OXFORDSHIRE COUNTY COUNCIL'S RESPONSE TO CONSULTATION ON THE FOLLOWING DEVELOPMENT PROPOSAL

Application no: 16/00627/REM

Proposal: Reserved Matters to 13/01811/OUT - Erection of 60 dwellings and public open space with associated works

Location: Land And Former Buildings UH11 442 465 466 467 468 470 471 481 492 493 529 593 596 Dow Street Upper Heyford

DETAILS: PROPOSED ENGINEERING LAYOUT
SHEET 1

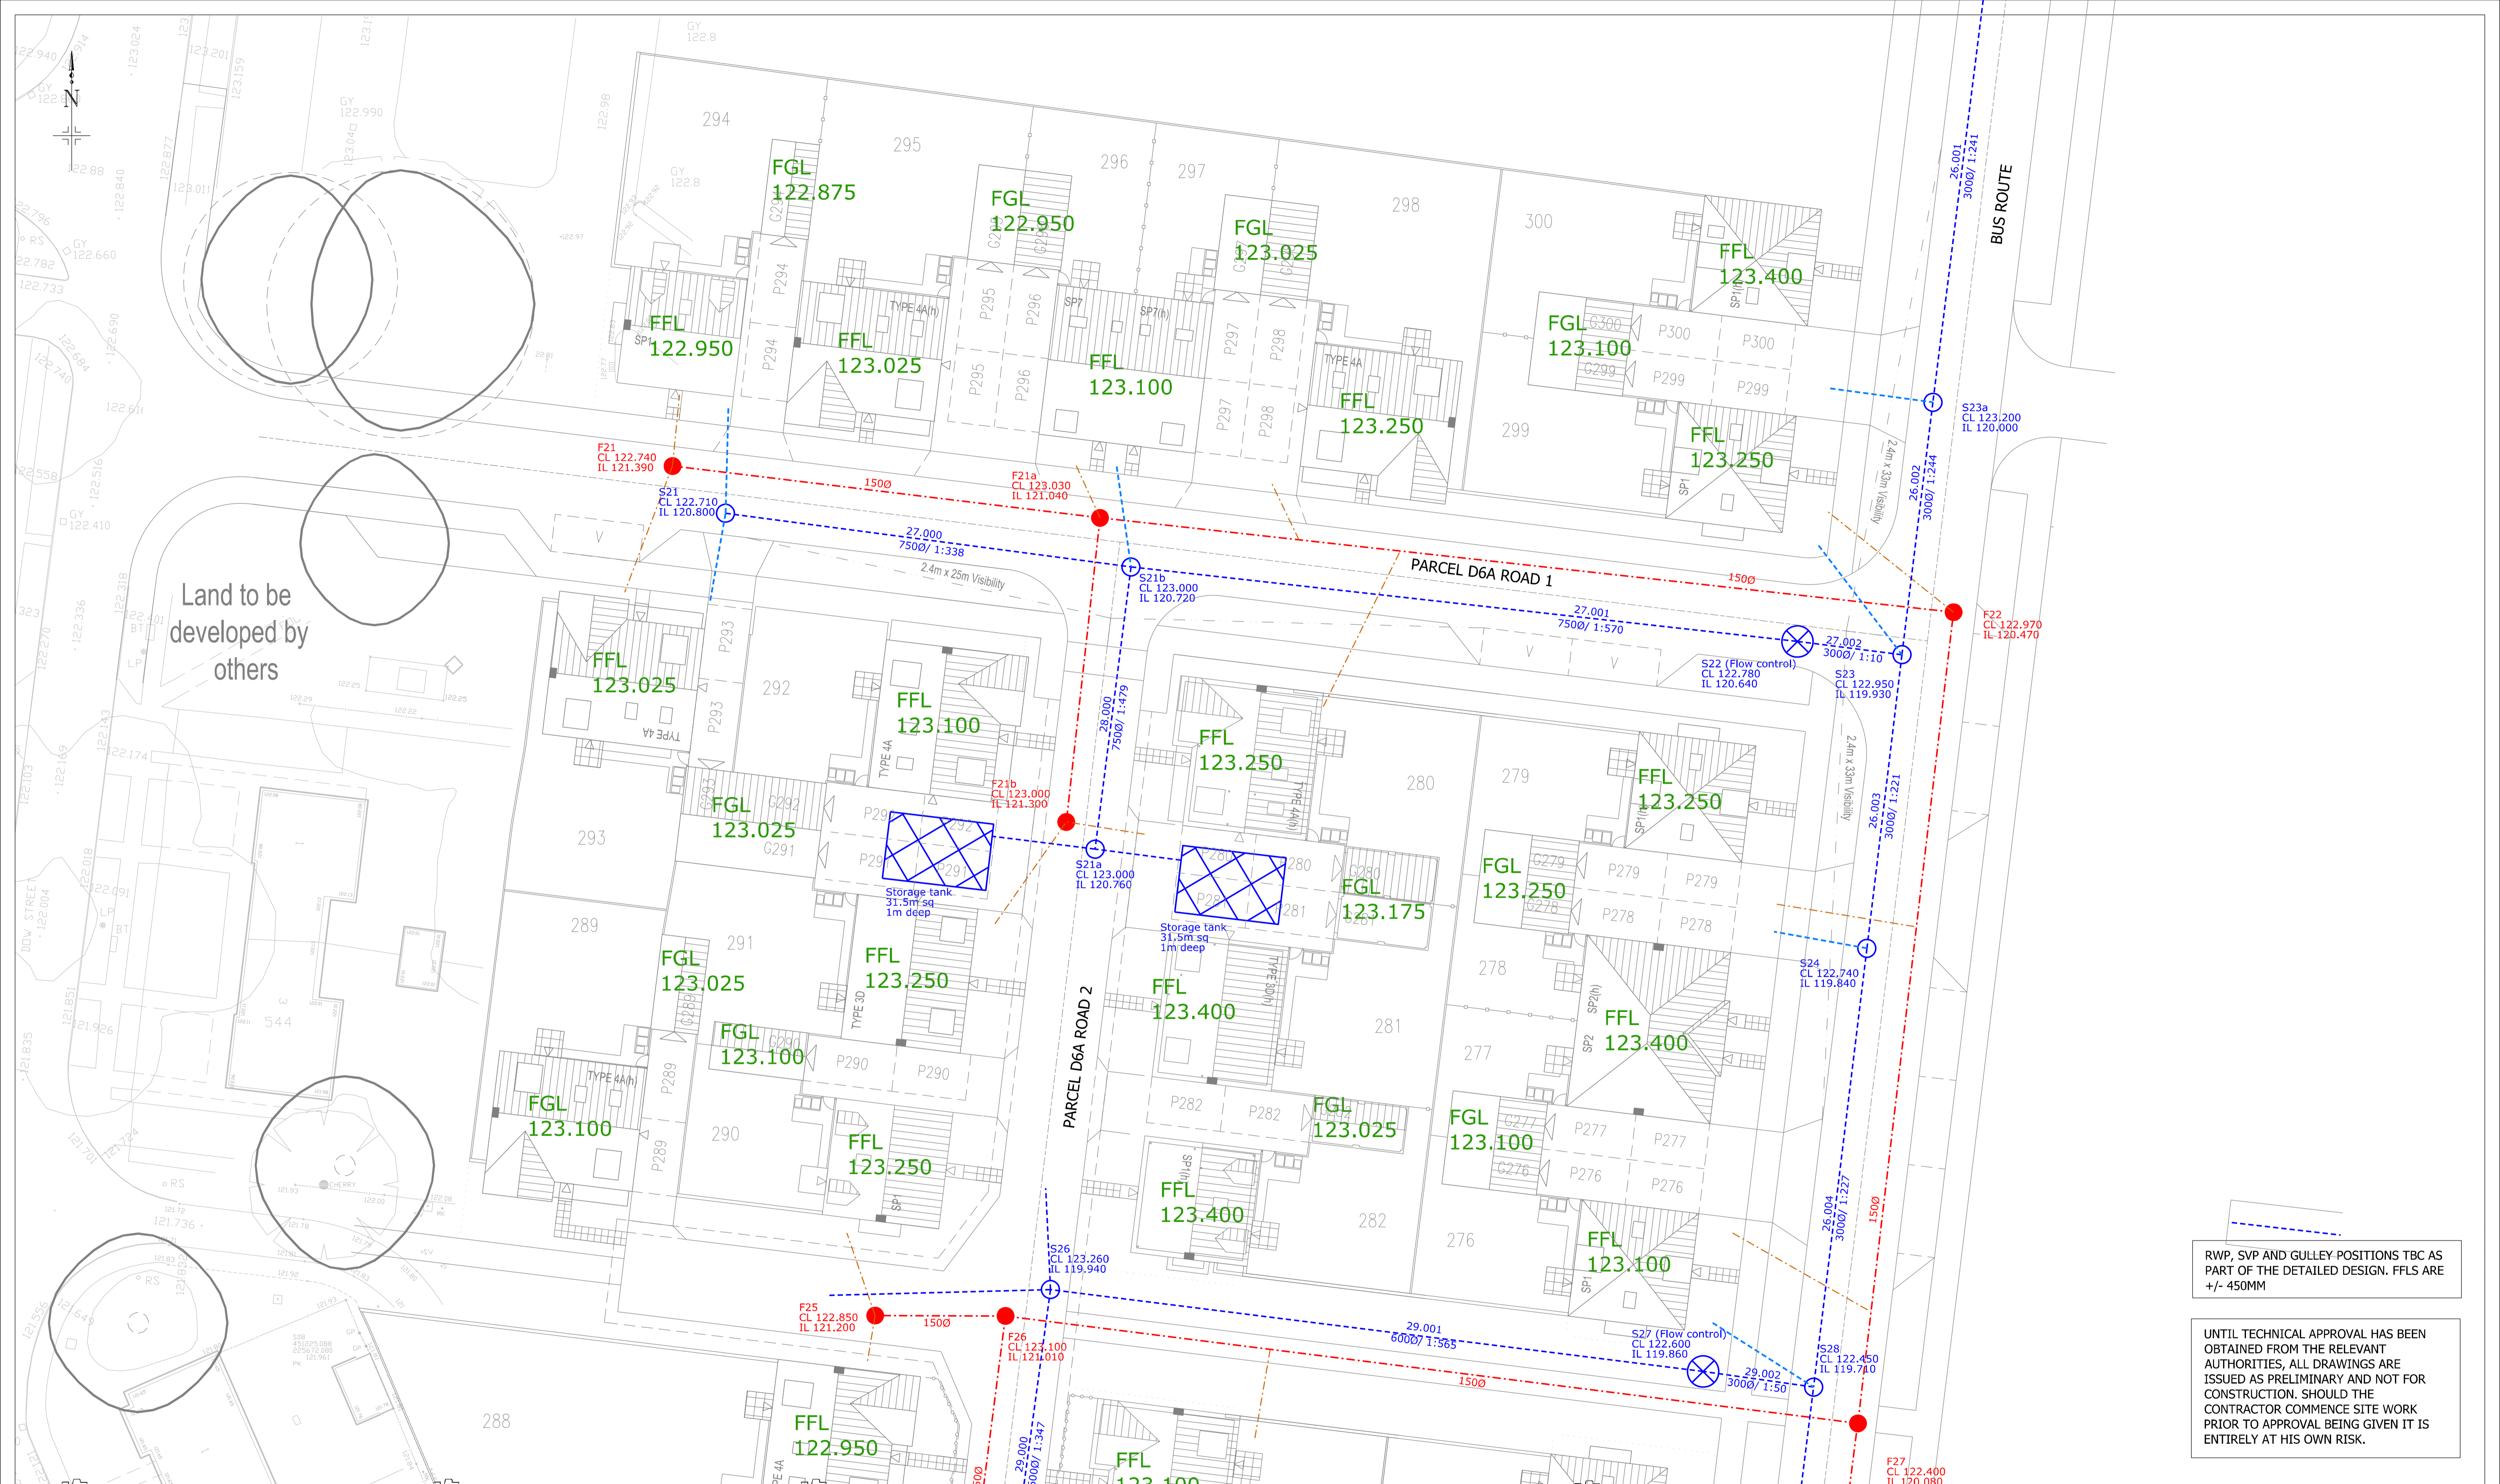
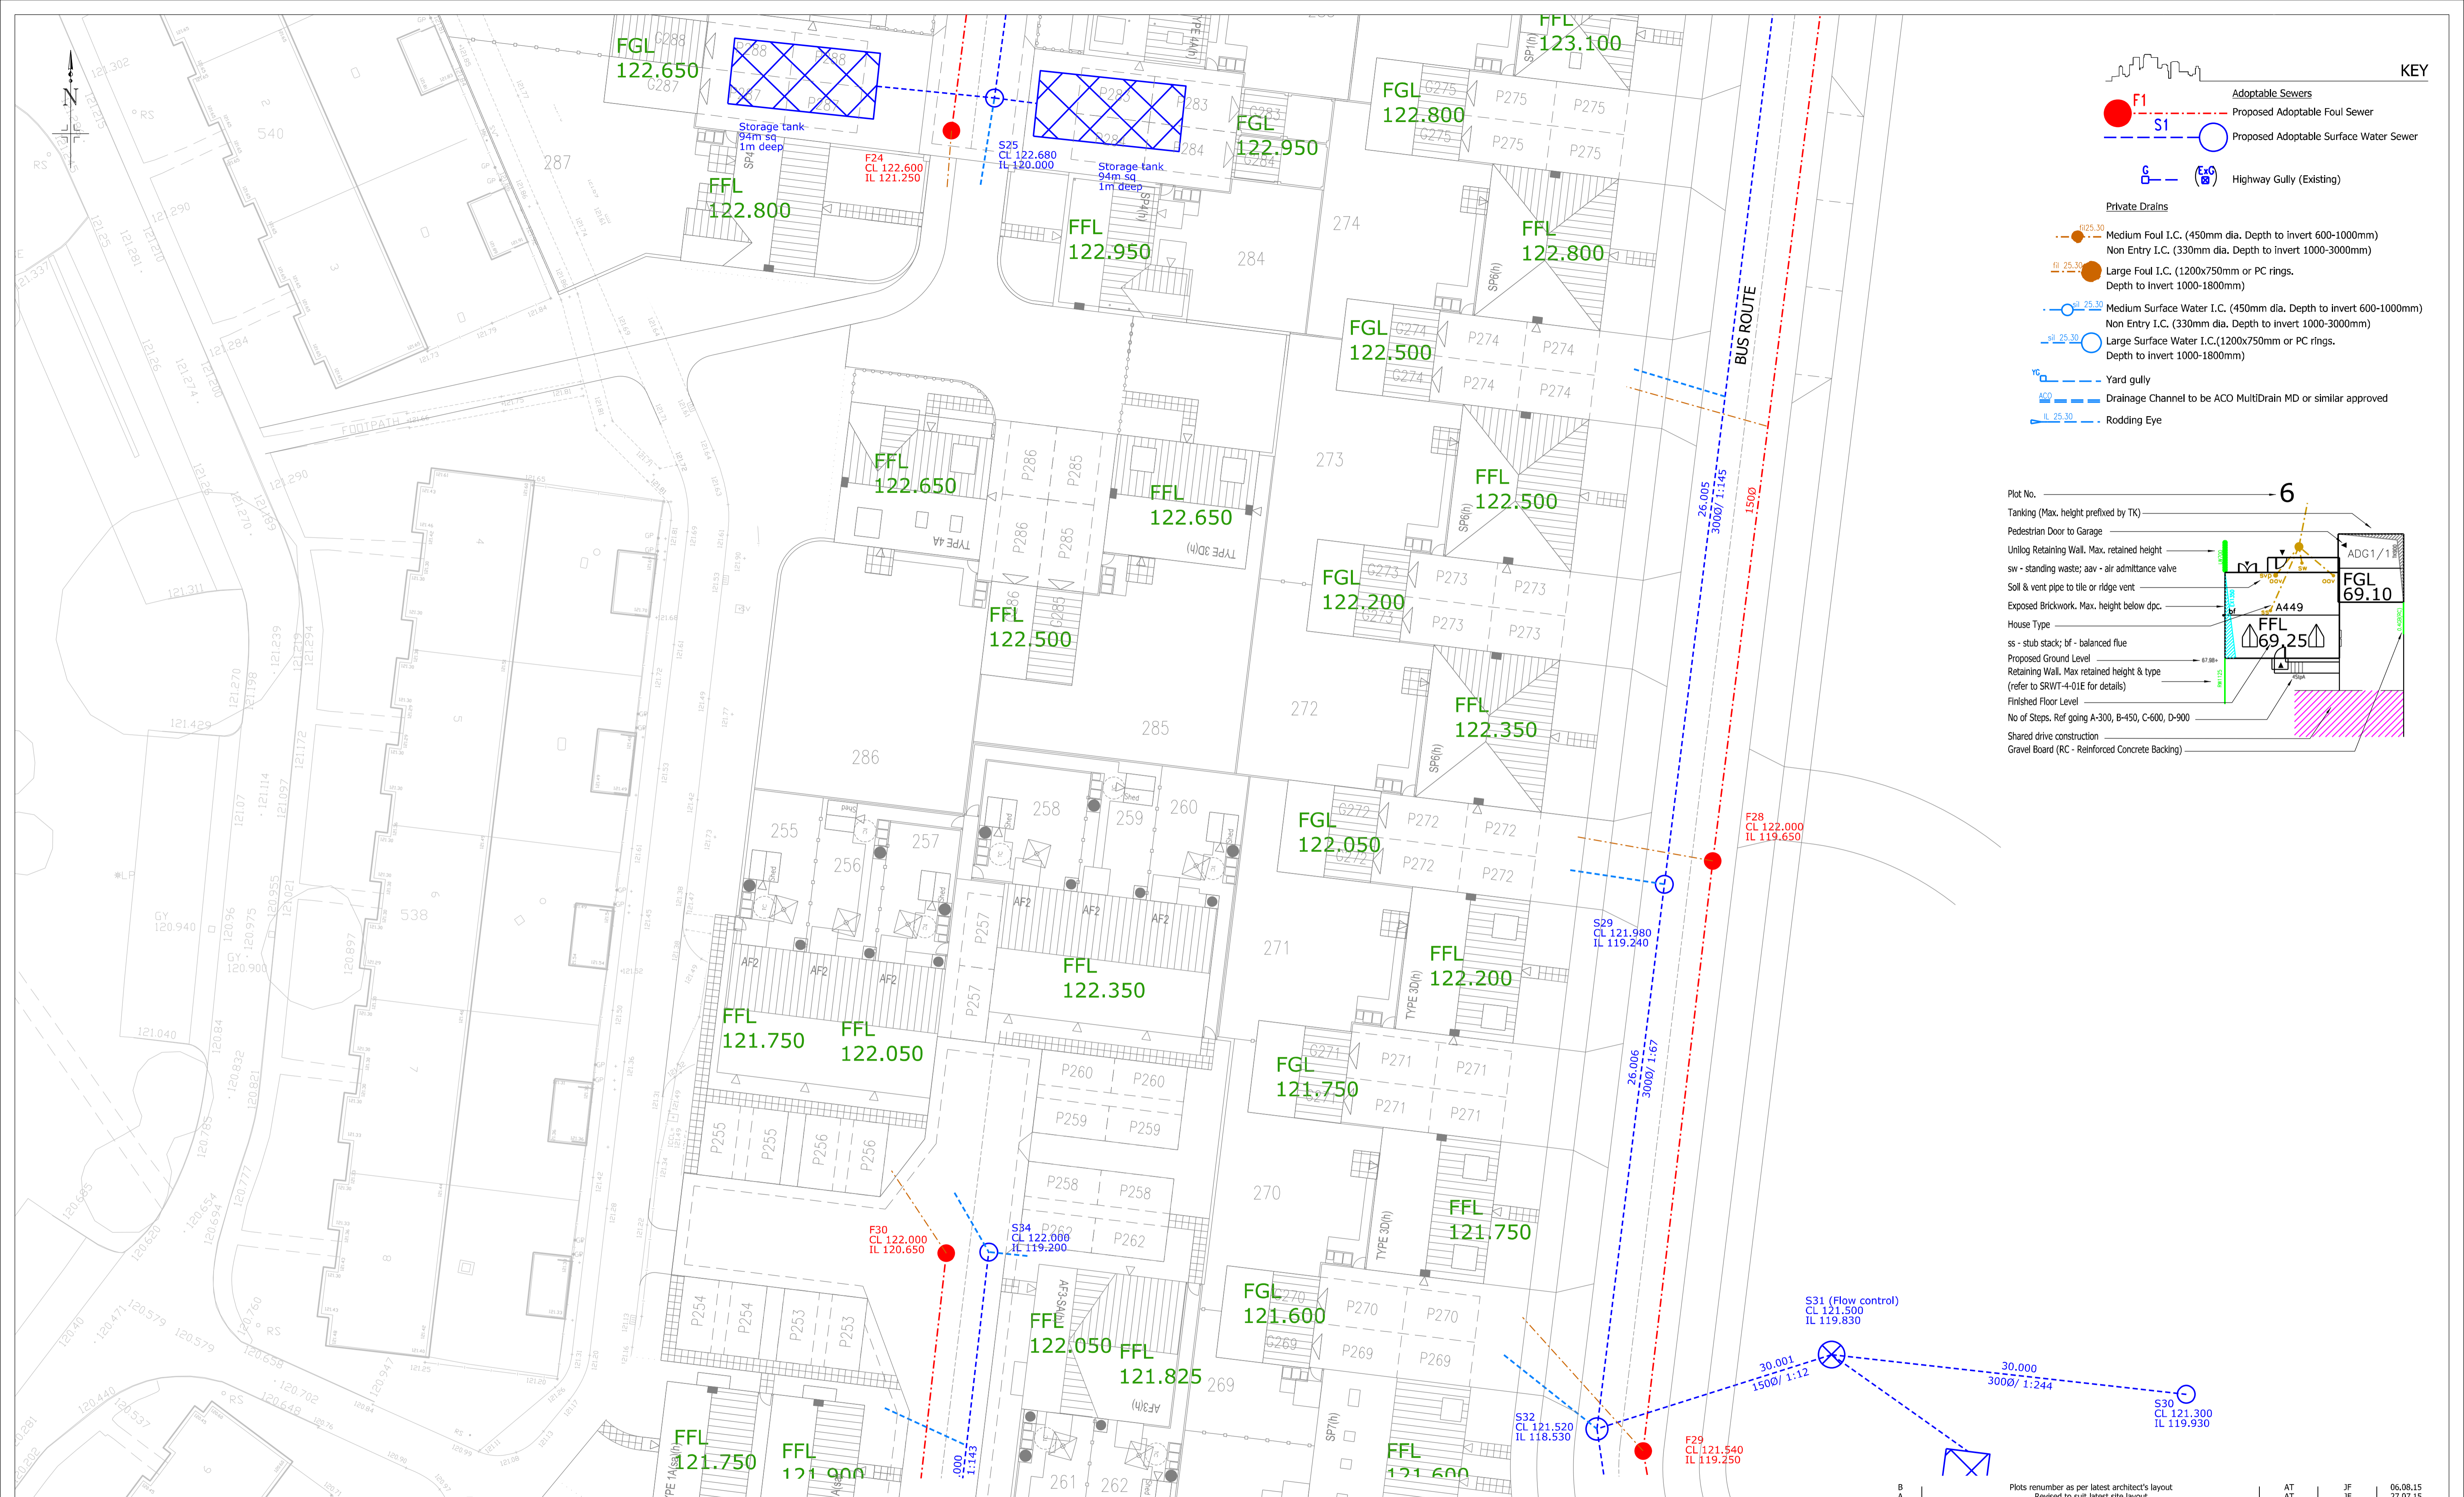
The refuse vehicle swept path analysis shows overhang of verges and footways in some locations. This will need to be rectified. **Reason for objection.**

The footpath link opposite plot 288 should be widened to match the required emergency access width of 3.0m and removable bollards should be installed at the location where shared surface commences. **Reason for objection.**

The junction opposite plot 282 should be re-aligned to accommodate refuse vehicles manoeuvring within the carriageway without overhanging footpath and verges. Tracking analysis for refuse vehicles will require re-submission. **Reason for objection.**

As refuse vehicles will be accessing the shared carriageway, the carriageway width of the shared surface should be at least 6.0m wide with a service strip either side to provide a level of safety for pedestrians and parked vehicles. **Reason for objection.**

In terms of drawings the drainage details supplied are inadequate. Outline SUDS drawings of the proposed system should be supplied. Currently a sketch of what appears to be drains and chambers is seen in the landscape proposals. **Reason for objection.**
